NSW RURAL FIRE SERVICE

Your reference: SSD-10477
Our reference: DA20200706002399-SEARS-1

Development Application
State Significant - SEARS - Warehouse or Distribution Centre
Hollinsworth Rd Marsden Park NSW 2765 AUS, (none)

Figure 10 | Site plan

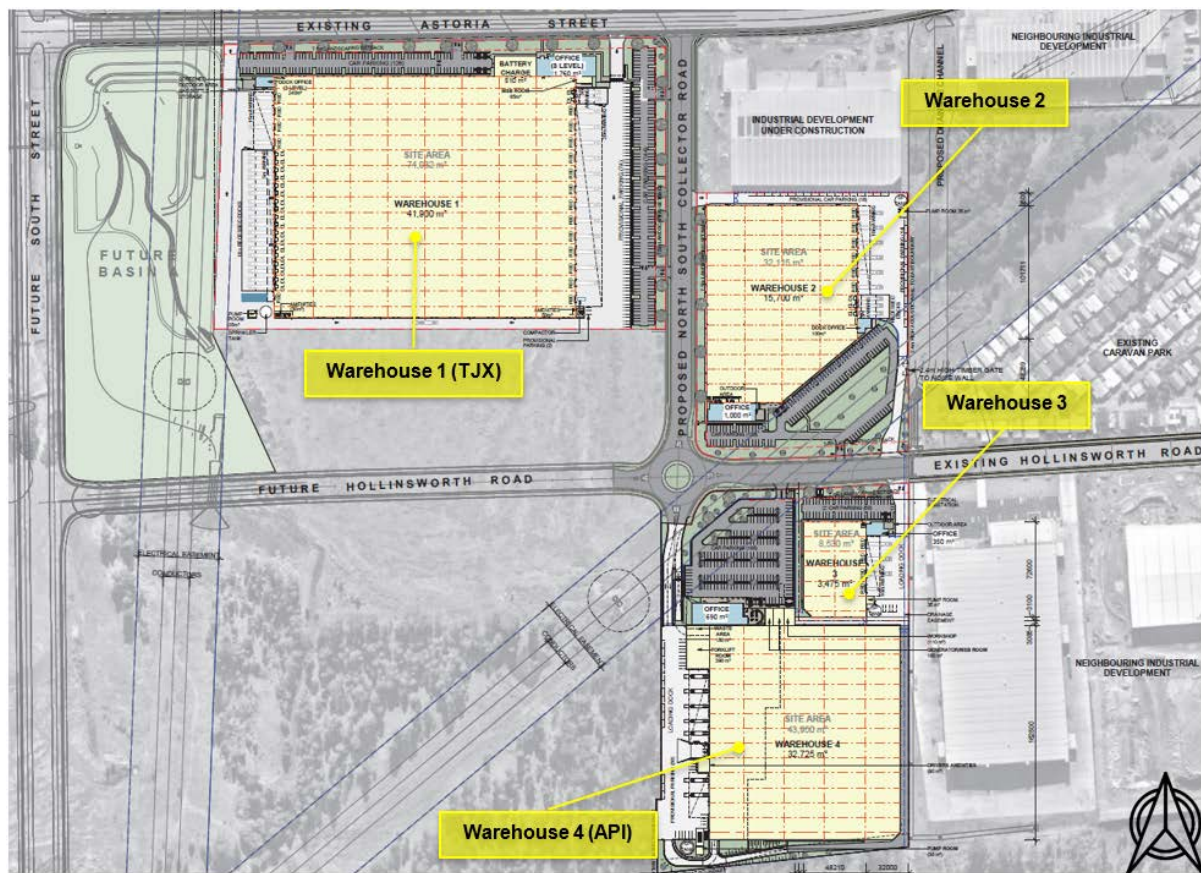
The proponent should also consider providing a separation between proposed Warehouse 4 and bushland in the south to prevent potential flame contact, otherwise, the building will require BAL Flame Zone or 40 construction, which may be impractical. In addition, the suitability and siting of any proposed fuel storage tanks must be addressed and located away from potential exposure to bush fire attack.
